**DEPARTMENT OF THE ARMY
WILMINGTON DISTRICT, CORPS OF ENGINEERS**

ORM ID SAW-2007-00157-164

Reference the Department of the Army permit issued to you on May 21, 2009, for the Rocky Mount Northern Connector, TIP R-2823, starting from SR 1604 (Hunter Hill Road) and ending at US 301, in Nash County and your written request of June 11, 2009, for permit modification. The permit modification requests are as follows:

Subject: MODIFICATION to 401 Water Quality Certification Pursuant to Section 401 of the Federal Clean Water Act and TAR-PAMLICO BUFFER RULES with ADDITIONAL CONDITIONS for Proposed Rocky Mount Northern Connector in Nash County, State Project No. 34509.1.1, TIP No. R-2823. DWQ Project No. 20081859 ver. 2.

PROJECT REFERENCE NO.	SHEET NO.
R-2823	7
ROADWAY DESIGN ENGINEER	HYDRAULICS ENGINEER
REVISED 06/10/99 PERMIT DRAWING SHEET 14 OF 68

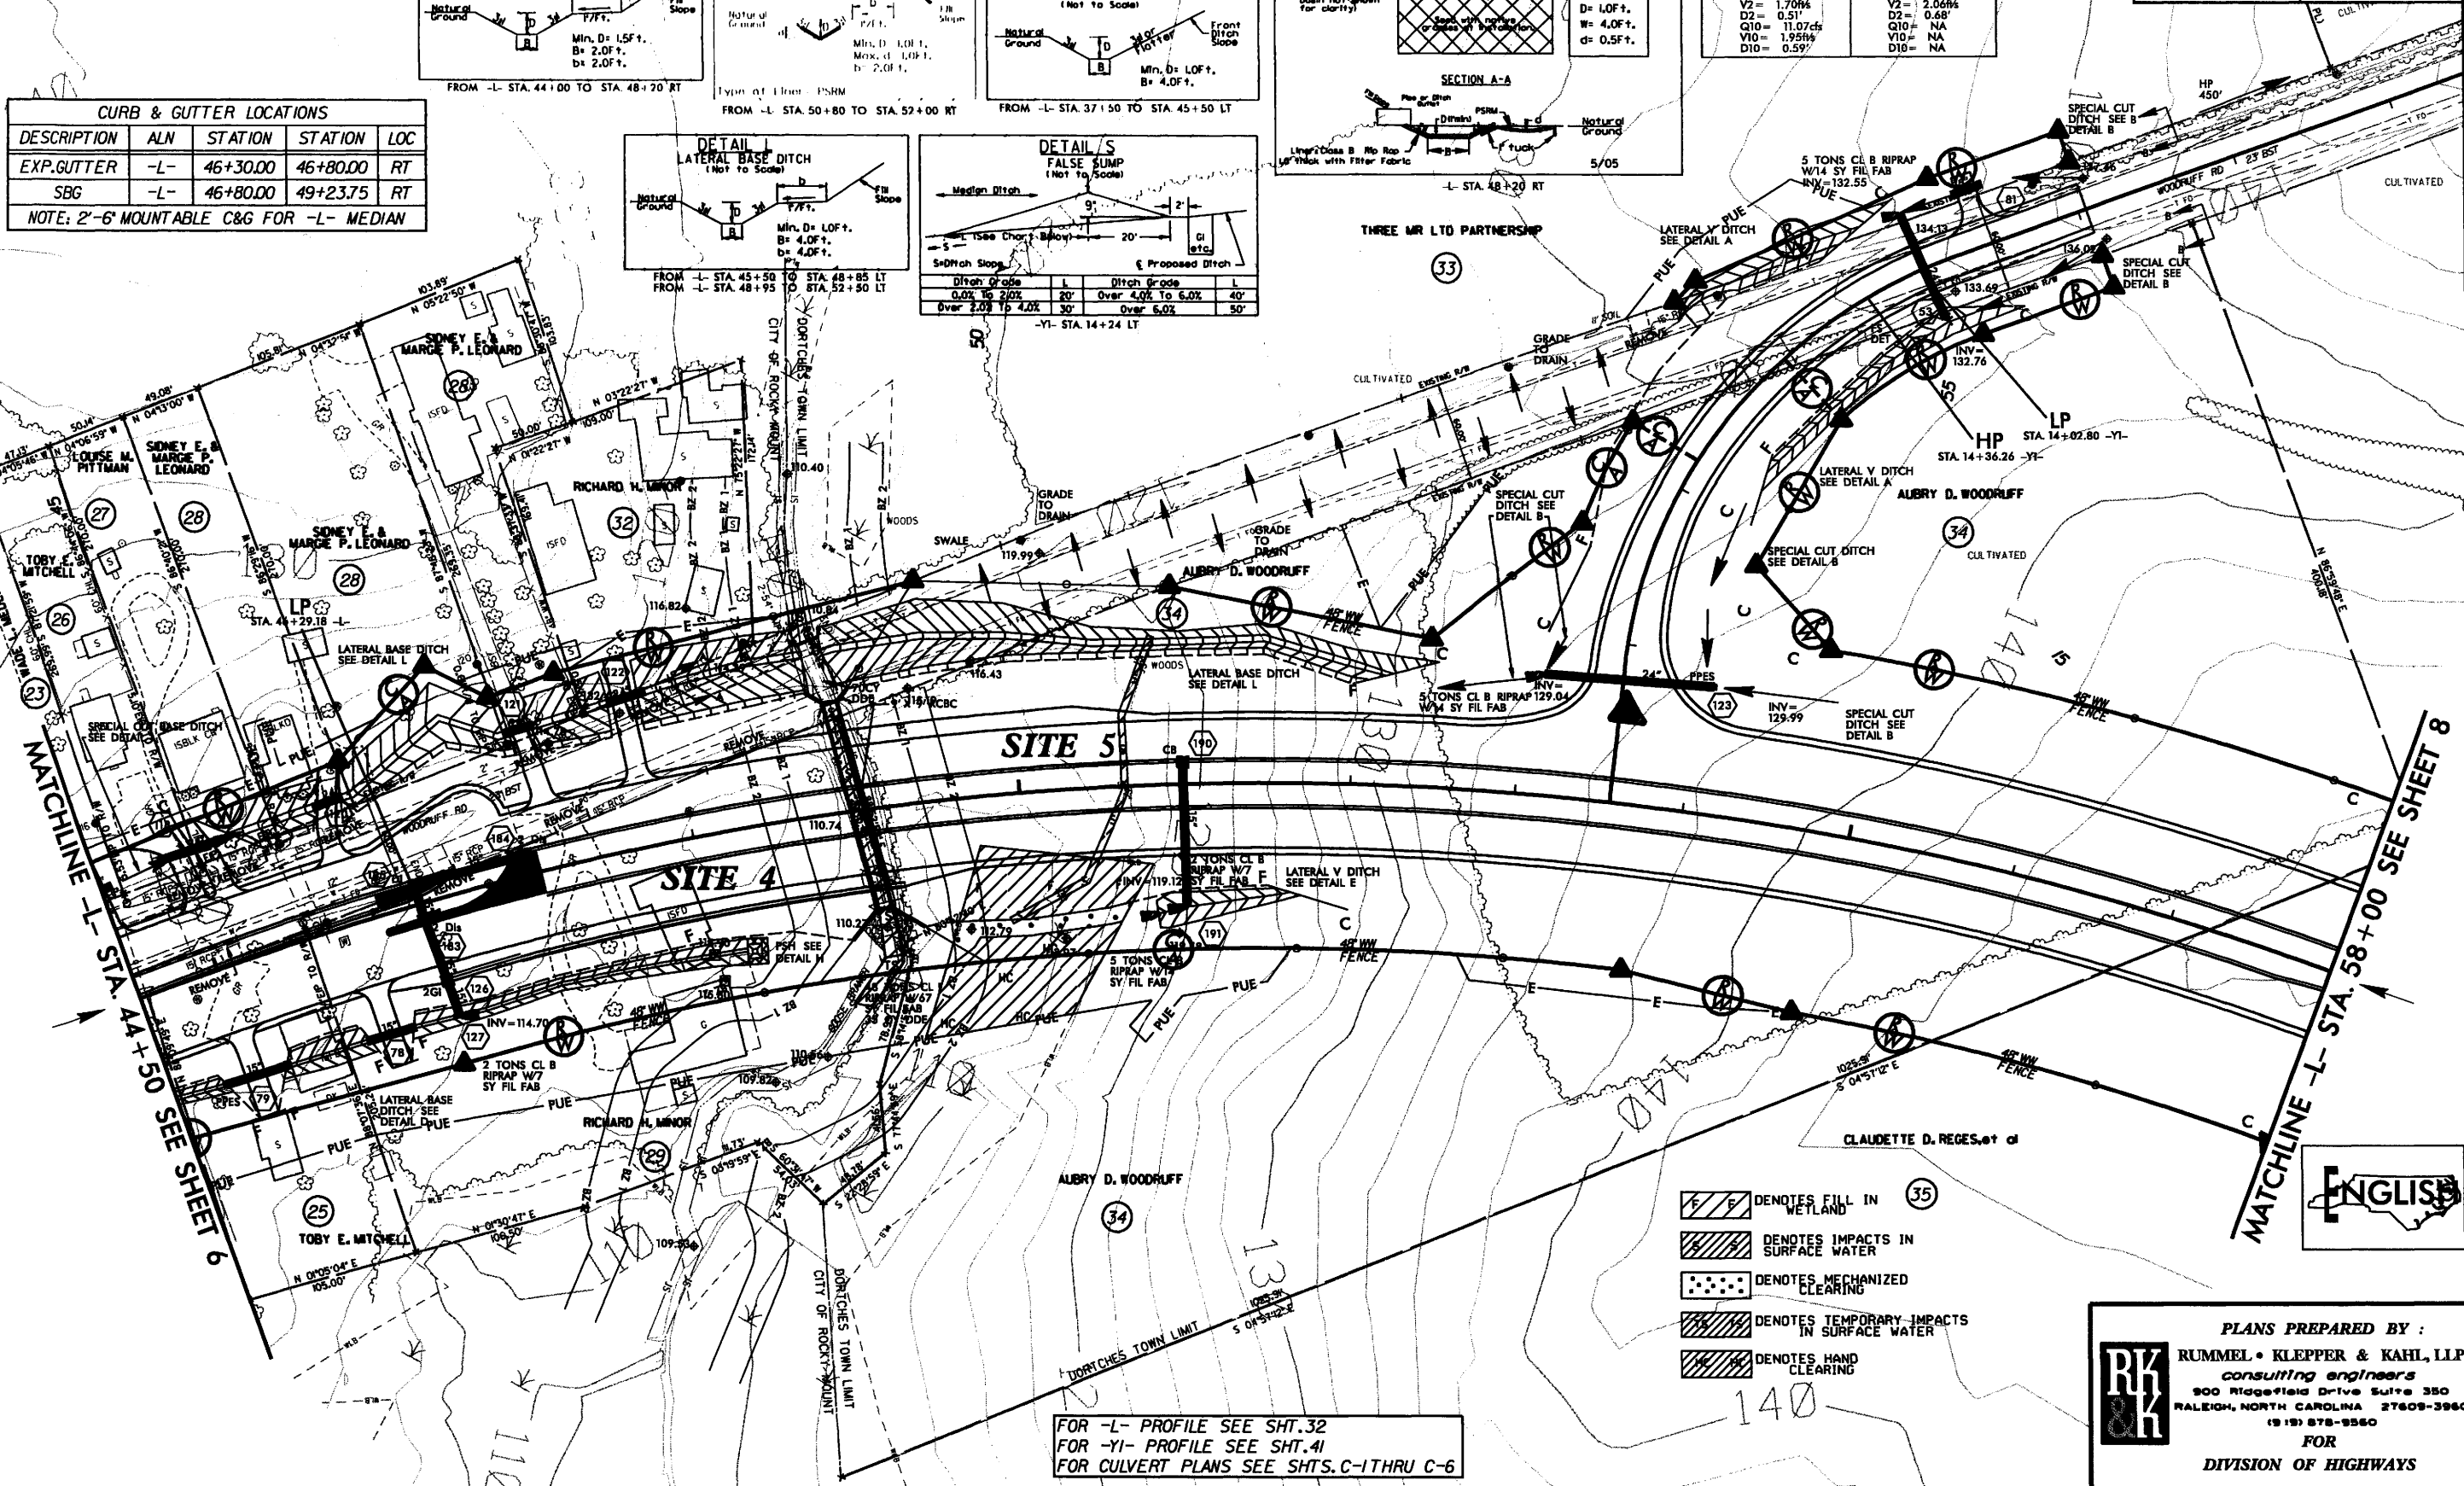
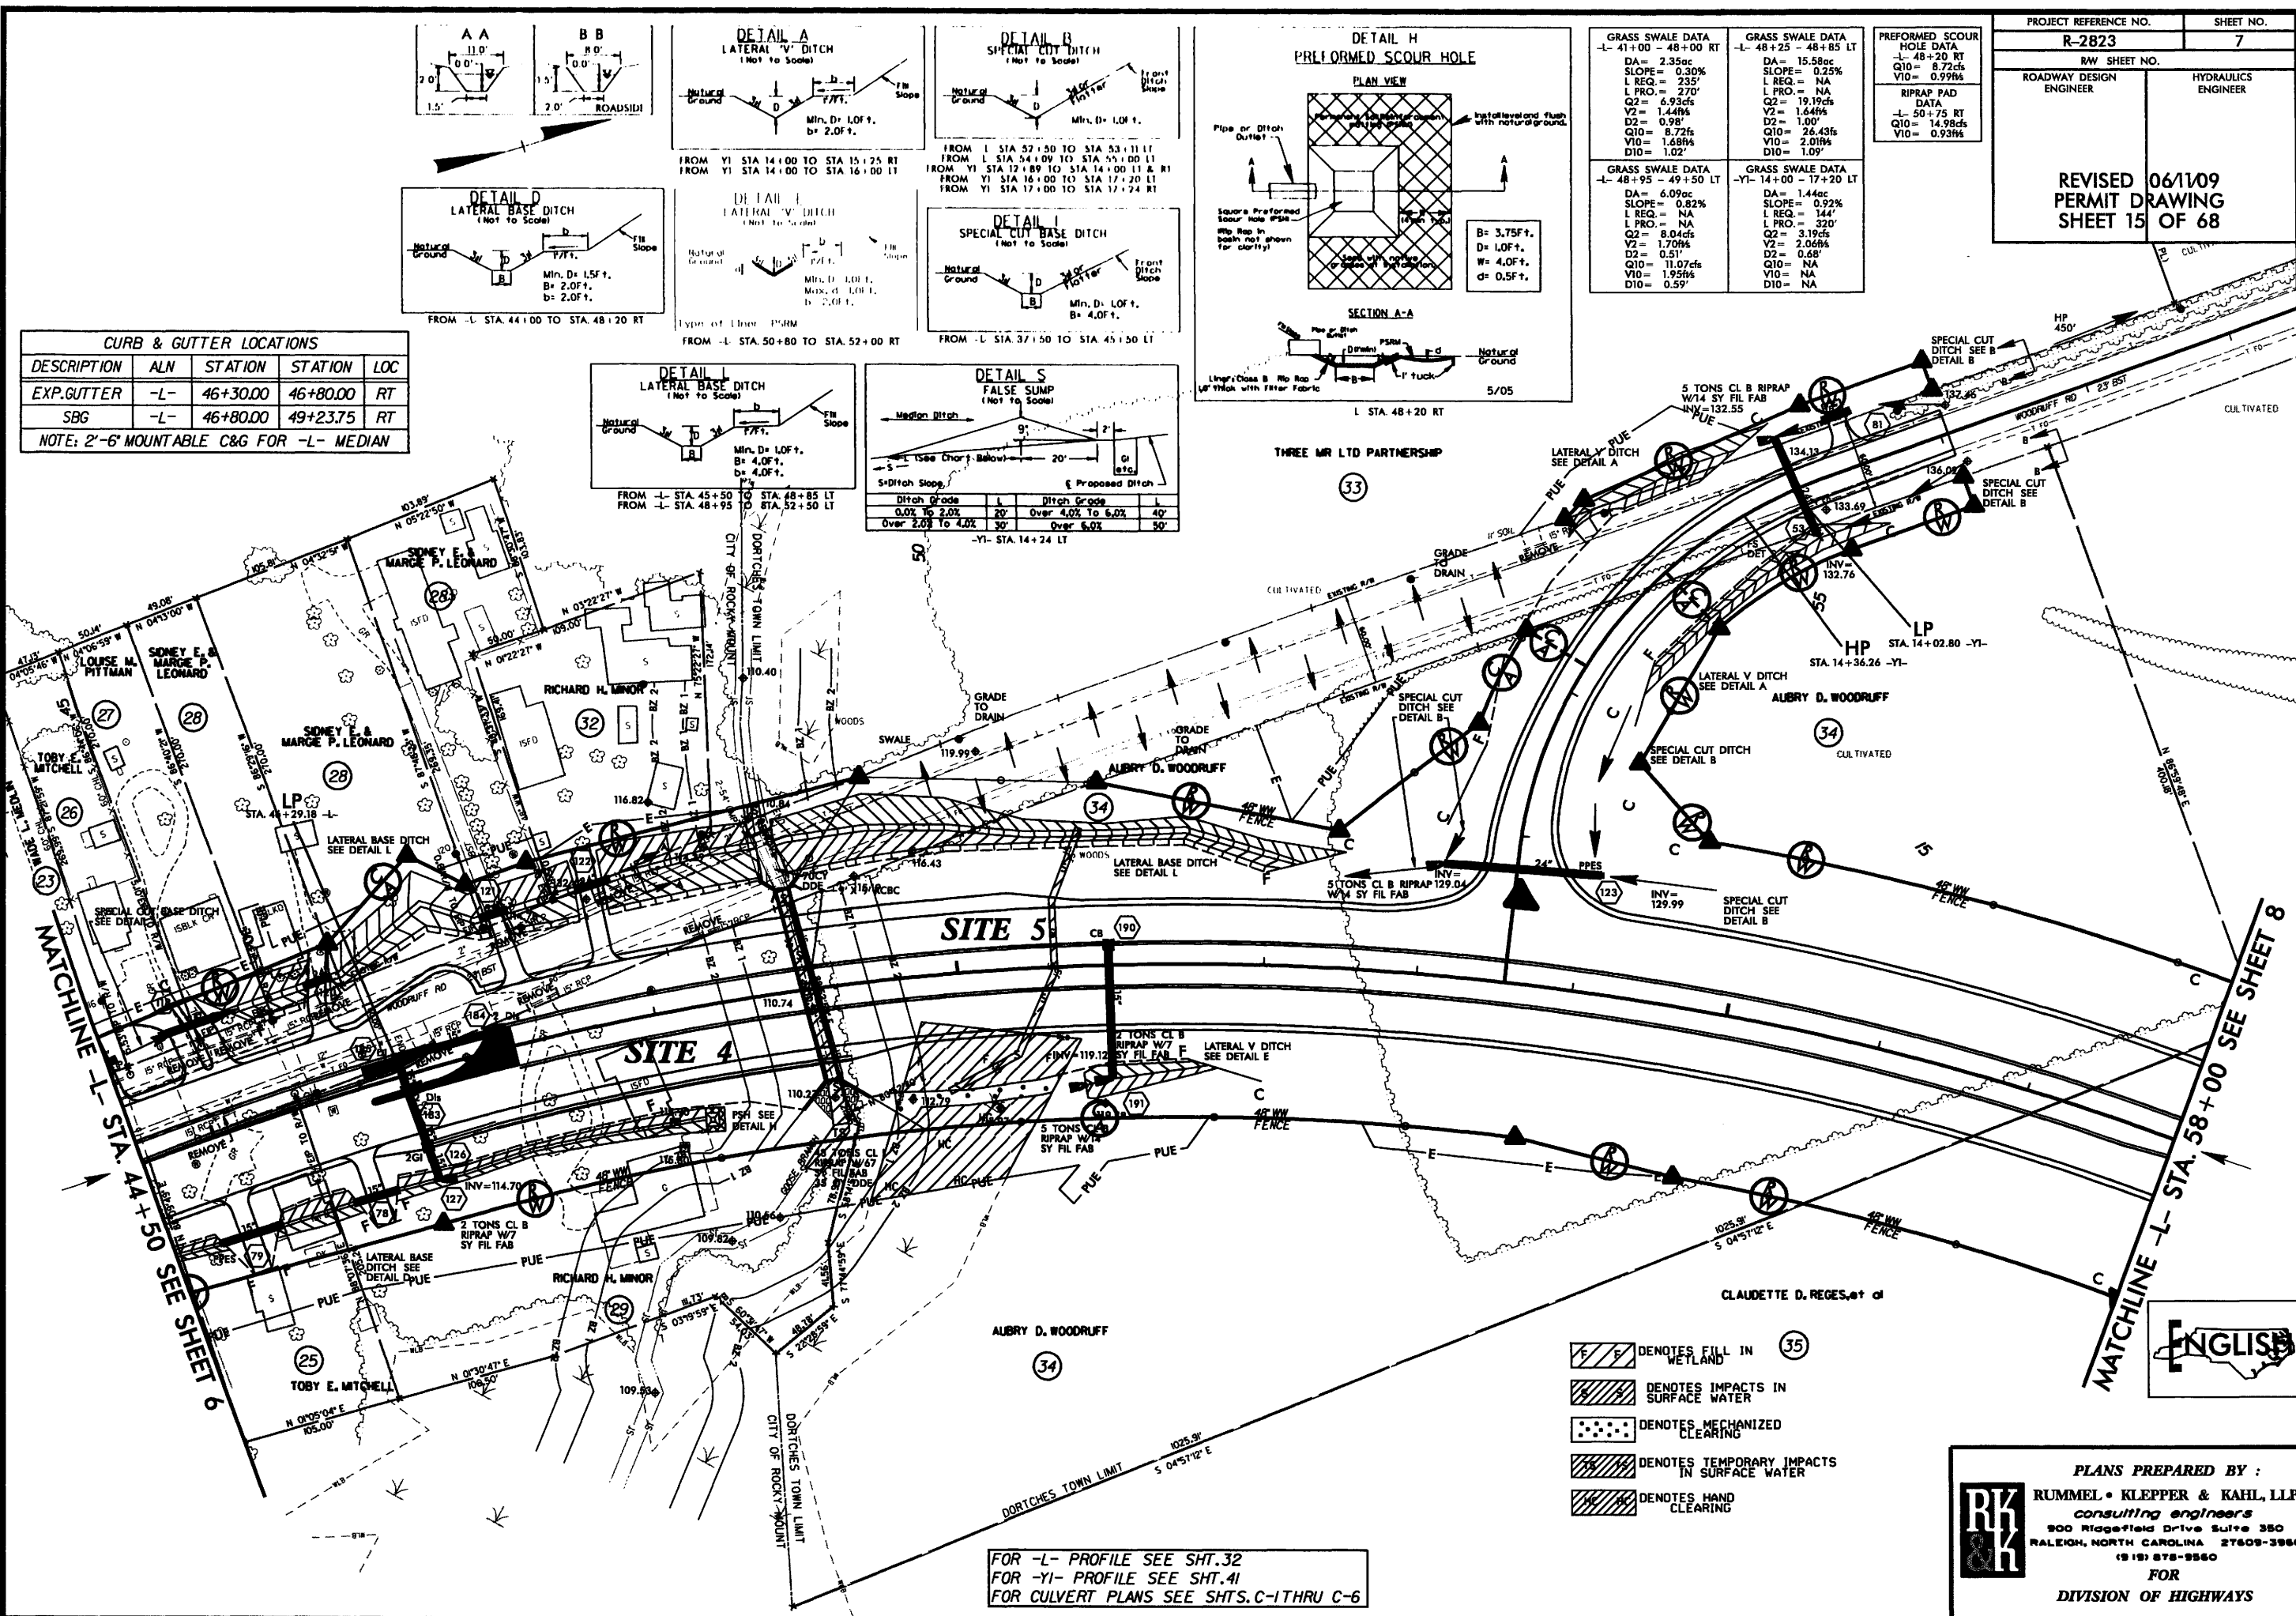
Site 1	Sheets 7 & 8	Additional wetland impacts: 0.01 acre of fill; 0.02 acre of mechanized clearing; 0.08 acre of hand clearing
Site 3	Sheets 11 & 12	Additional wetland impacts: 0.02 acre of fill; 0.04 acre of hand clearing
Site 5	Sheets 14 & 15	Additional wetland impacts: 0.11 acre of hand clearing
Site 13	Sheets 43 & 44	Additional wetland impacts: 0.05 acre of fill Reduced wetland impacts: 0.01 acre of mechanized clearing Additional stream impacts: 13 linear feet
